East Anglia ONE North and East Anglia TWO Offshore Windfarms

Applicants' Responses to Examining Authority's Written Questions

Volume 5 – 1.3 Compulsory Acquisition, Temporary Possession and Other Land or Rights Considerations

Date: 2nd November 2020

| East Anglia TWO Offshore Wind Farm | | | Drg No | EA2-DEV-DRG-IBR-000693 | |

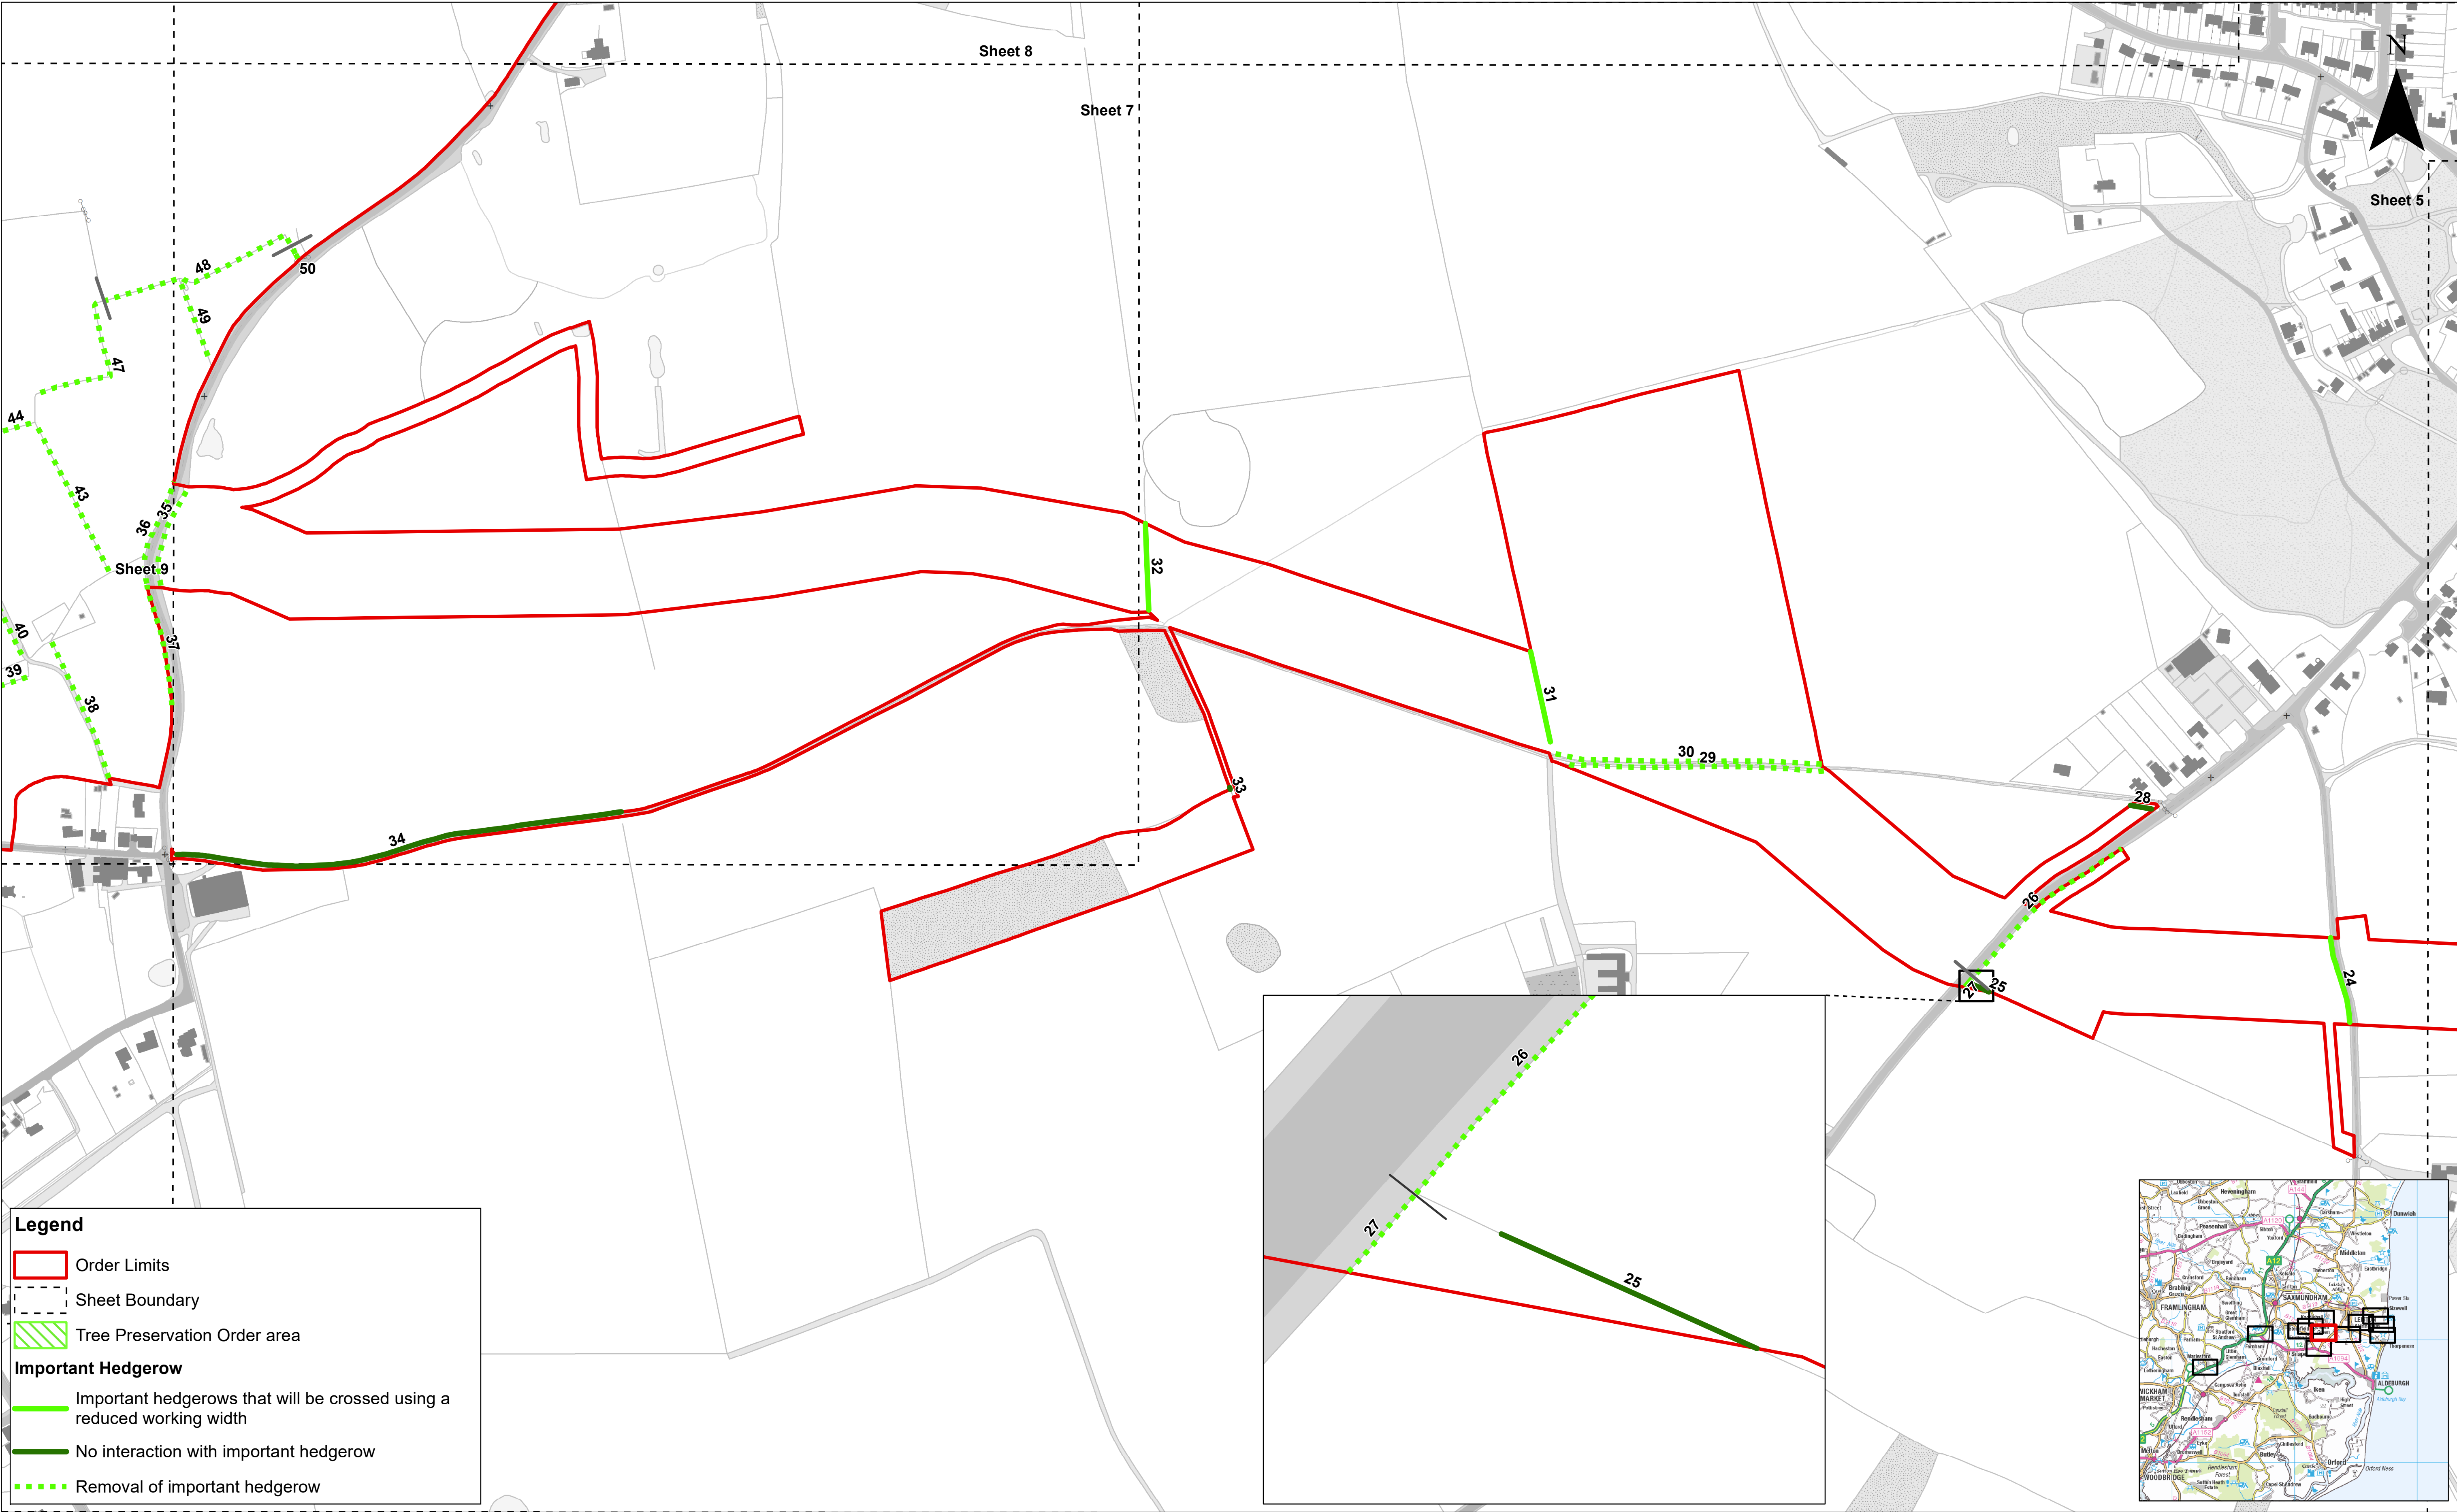
1.3.34	The Applicant	<p>1 2</p> <p>Schedule 11 part 2 lists important hedgerows that will be crossed using a reduced working width with reference to the important hedgerows and tree preservation order plan [APP-020].</p> <p>Please include in the crossing schedule and plan requested</p>	<p>This information is included in the Onshore Crossing Schedule which can be found in Appendix 7 of this document.</p>

ExA. Question Ref.	Question addressed to	ExA. Question	Applicants' Response
		elsewhere in this question set details of important hedgerows crossed, specifying the necessary width and the crossing method to be used in each case.
